OBJECTIONS

The very short exhibition period (21 July to 3 August 2026) does not allow stakeholders to undertake appropriate due diligence on the Lourdes Retirement Village Proposal SSD-88004956 (**the Proposal**).

Figure 4 Proposed Variation to the Housing SEPP 9.5m habitable and 11.5m services height control
Source: PBD Architects

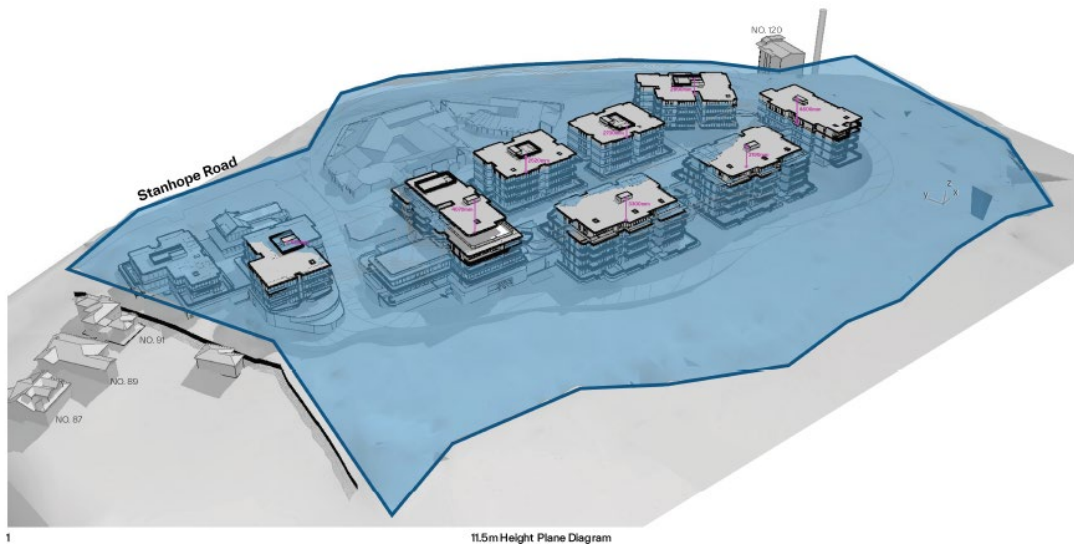
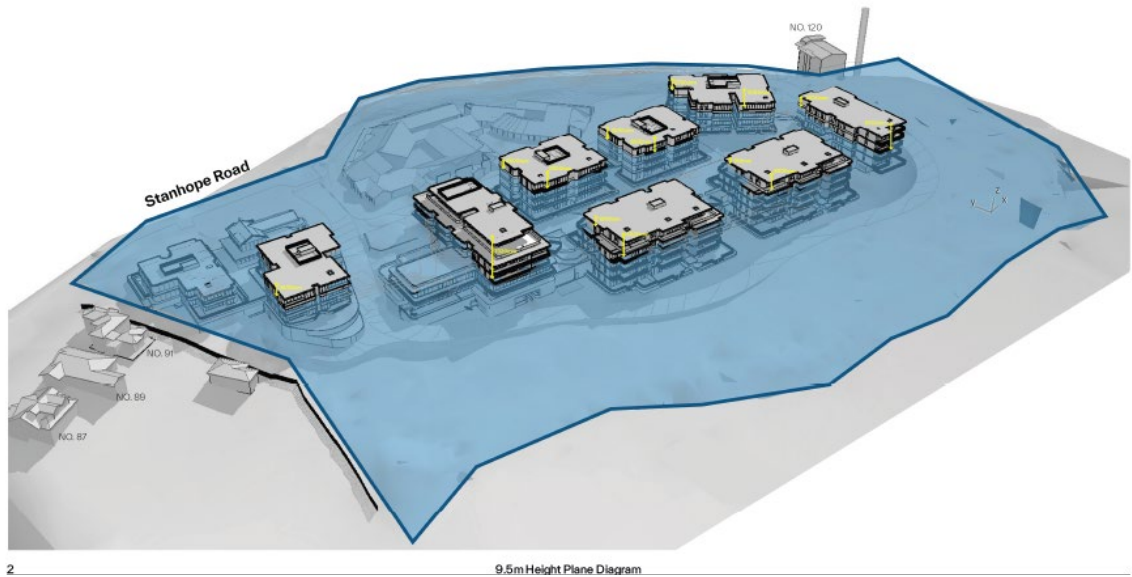
At its highest point at the southern end of Building A , which is located within the lower portion of the site the building reaches a maximum height of 18.4m. This represents a maximum variation of 6.9m to the 11.5m height control under the Housing SEPP. The areas of exceedances are away from the more sensitive interfaces at Stanhope Road and to the west of the site. They are localised, have negligible view impact, centrally located within the site, below street level and well setback from the site boundaries and limited to approximately 11.3% of the total site area, which is considered minor in nature."

An 18.4-metre height is about **5 to 6 stories** tall which is about three times the height of Headfort House. Based on diagrams A and B it would appear that the proposed new buildings would dwarf Headfort House and do not have negligible view impact or be minor in nature.

I request clarification of the proposed new buildings height as viewed from Stanhope Rd supported by artist's impressions allowing for proposed tree removals with detailed measurements (eg height and length of buildings as viewed from Stanhope Rd).
